From: Simon Davis
Sent: 19 August 2019 14:18
To: Planning Scanning
Subject: FW: BE/84/19/PL

From: stephen jupp [REDACTED] >
Sent: 18 August 2019 14:18
To: Simon Davis [REDACTED]
Cc: Fiona Dobbs [REDACTED]
Subject: BE/84/19/PL [REDACTED]

DRAWING TITLE
SITE LAYOUT - PHASE 4c

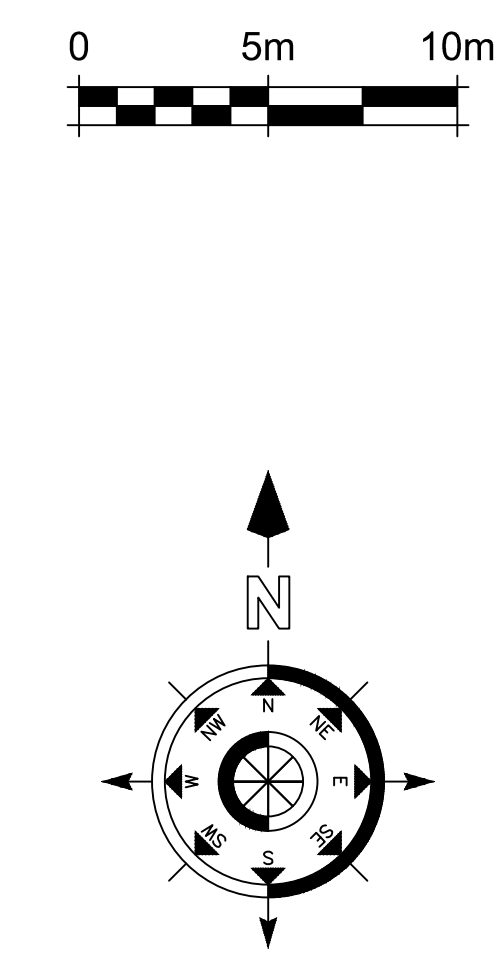
My objection is on a single issue, namely their failure to mention / address / retain the substantial landscape belt on the west boundary of 350 Chichester Road which was negotiated by me with the developers right at the beginning of the development and has now become well established and is CRITICAL in ensuring that our amenities are preserved.

As an aside there appears to be a compound appearing next to 350 Chichester Road - a compound in this location has never been agreed as far as i am aware and certainly the developers have not approached any of the local residents about this.
